Abercrombie Precinct Redevelopment
The University of Sydney Business School

Review of Planning Application Drawings - Final

Issued : 17 April 2012
File Name: E:\Access Associates\A10113\Report\DAReport.Doc
Client : The University of Sydney Campus Infrastructure & Services
Project Name: Abercrombie Precinct – University of Sydney Business School
Project Number: A10113

Drawing title
GROUND FLOOR PLAN

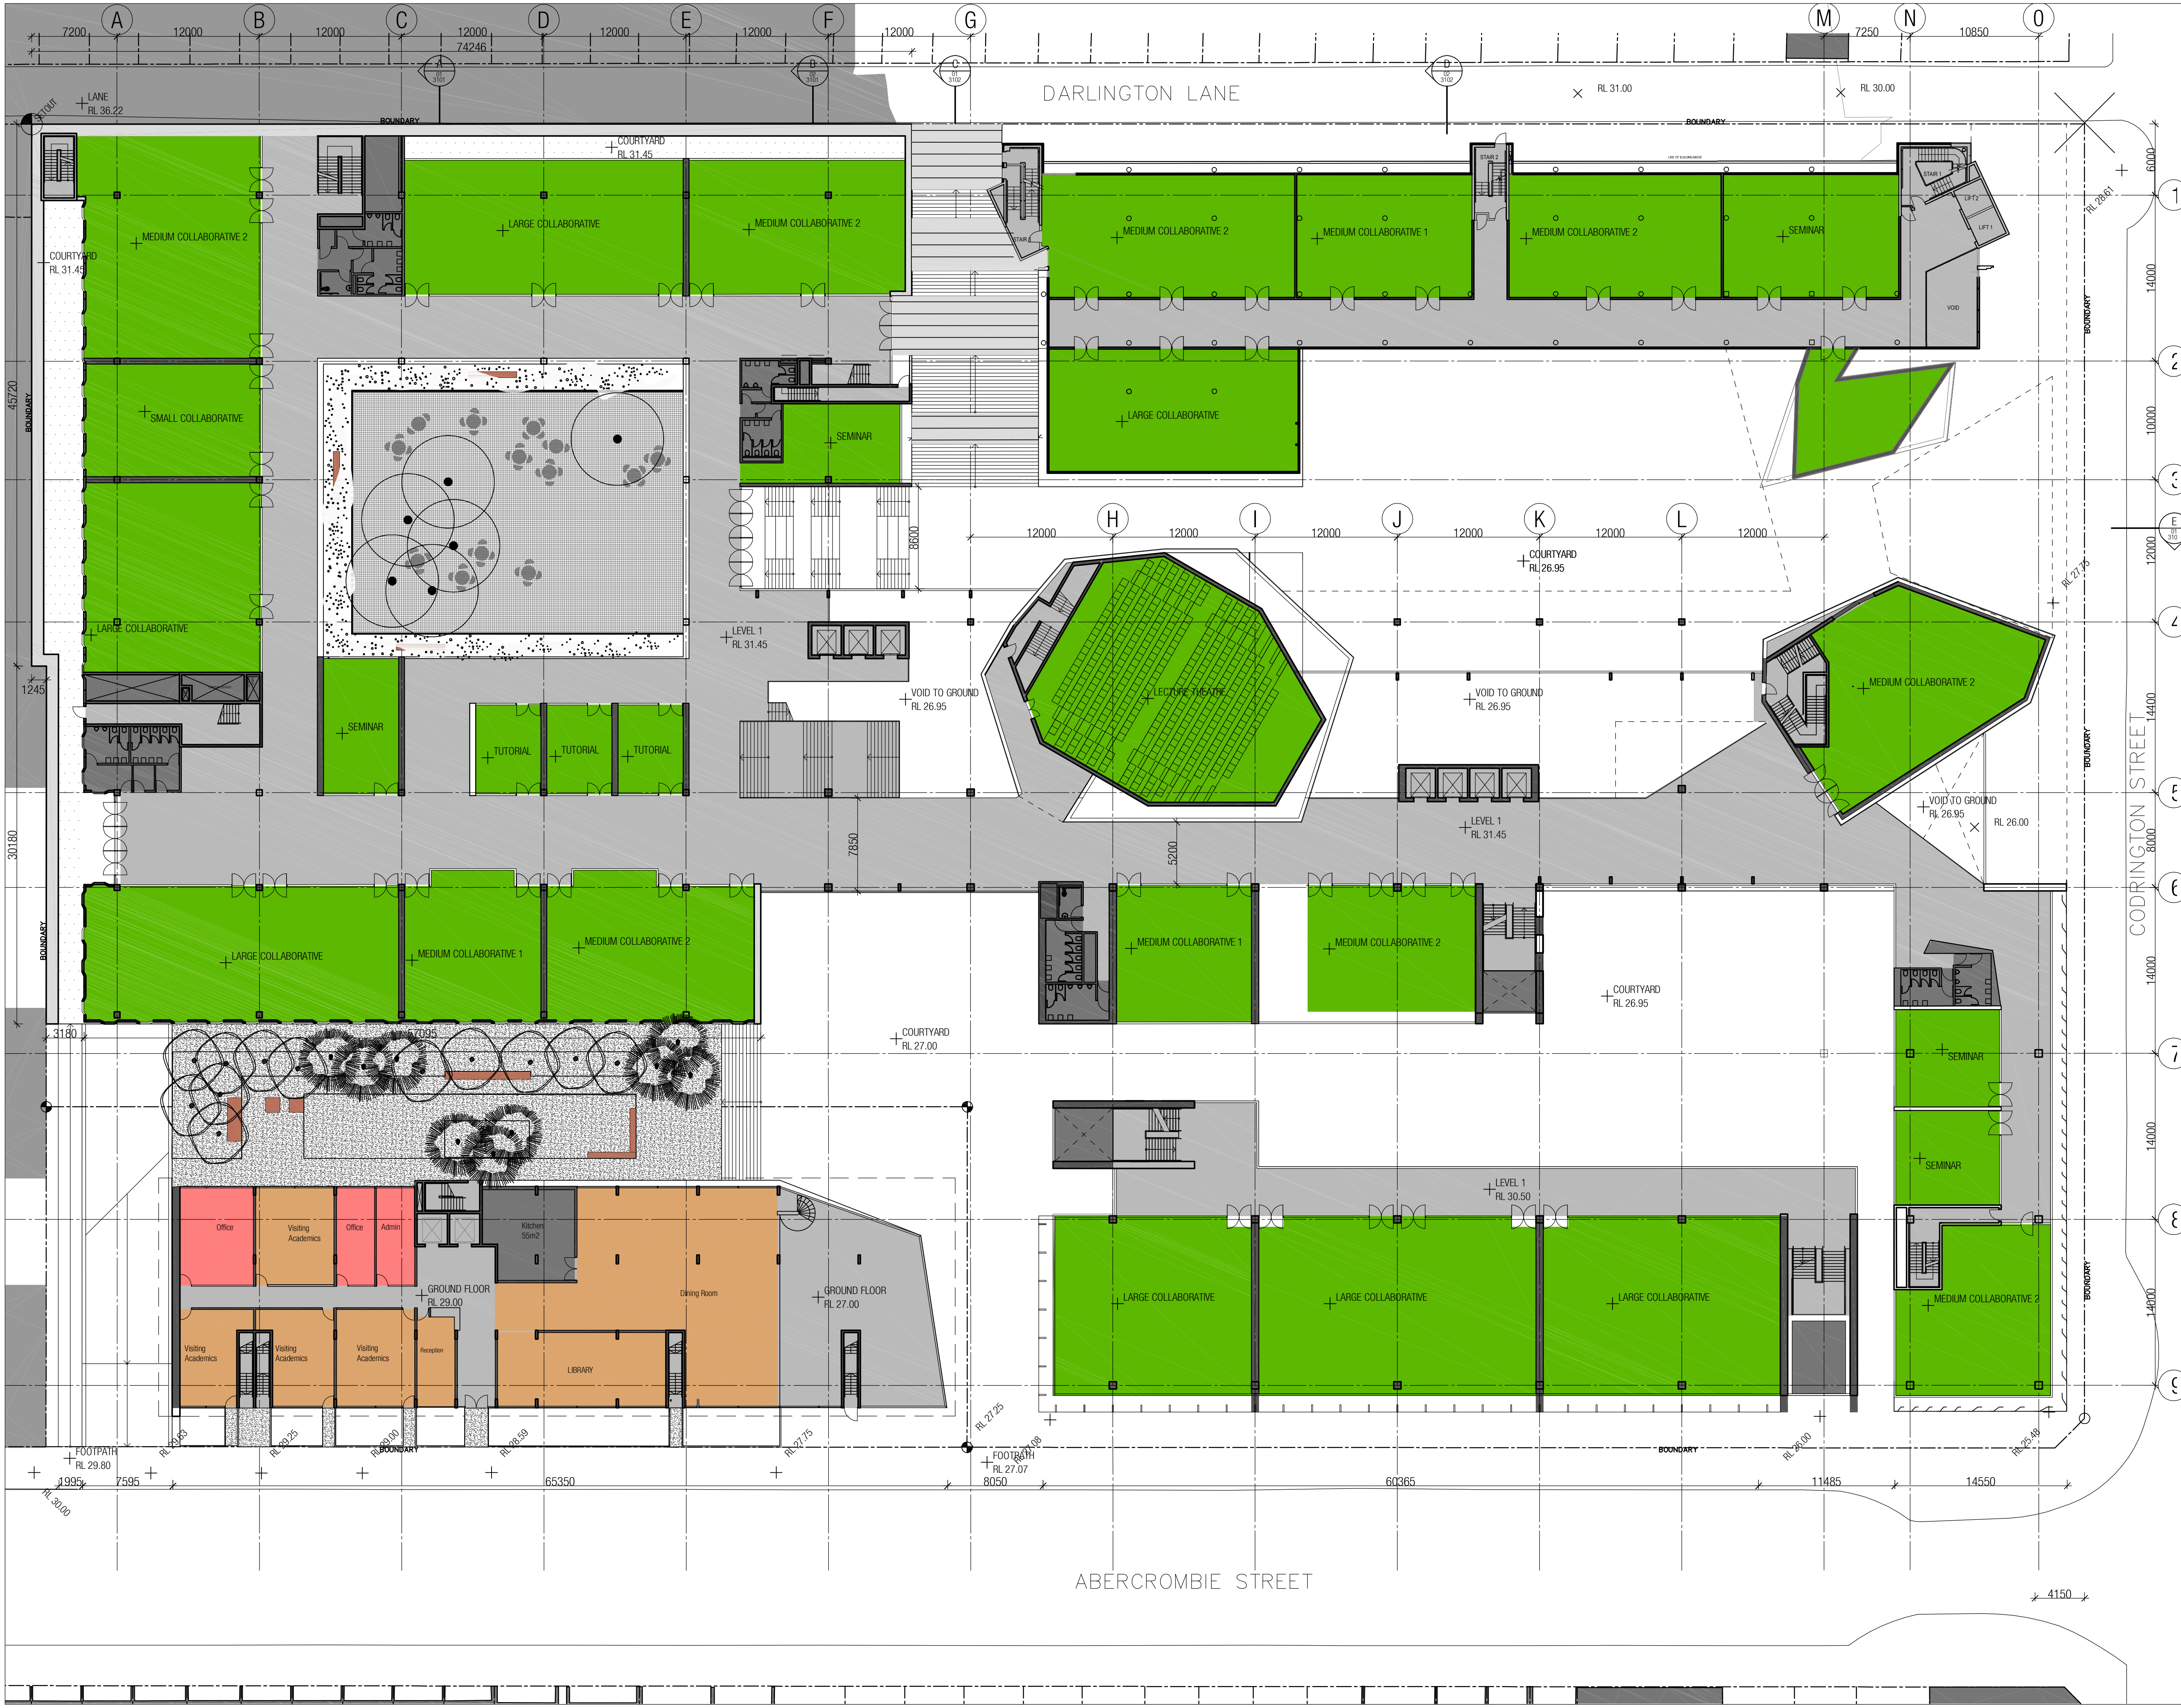
The ground floor includes an east west change in level which to meet the BCA part D3.2 is linked via an external pedestrian ramp and internal stairs and adjacent through car lifts.

- Lecture theatre – 550 seats (tiered fixed seating) – 6 wheelchair seating spaces are currently indicated in the rear row of seating. 11 spaces will be required to meet the BCA part D3.9.
An accessible path of travel, required for use by a presenter, is not currently indicated to the front of the lecture theatre

- Lecture theatre – 300 seats (tiered fixed seating) – 6 wheelchair seating spaces are currently indicated in the rear row of seating
An accessible path of travel, required for use by a presenter, is not currently indicated to the front of the lecture theatre.

- 3 Case Study rooms – 100 seats (tiered fixed seating) – 2 wheelchair seating spaces are currently indicated in the front row of each room
3 wheelchair seating spaces are required to meet the BCA part D3.9)
An accessible path of travel, required for use by a presenter, is indicated at the entry level to the front of the lecture theatre

- (iv) Ensure in ongoing design lecture theatres include wheelchair seating spaces to meet the requirements of the BCA D3.9 and AS1428.1 (2009) clause 18 to facilitate wheelchair access to the proposed fixed seating areas and for a person requiring access to the front of the room to lecture.
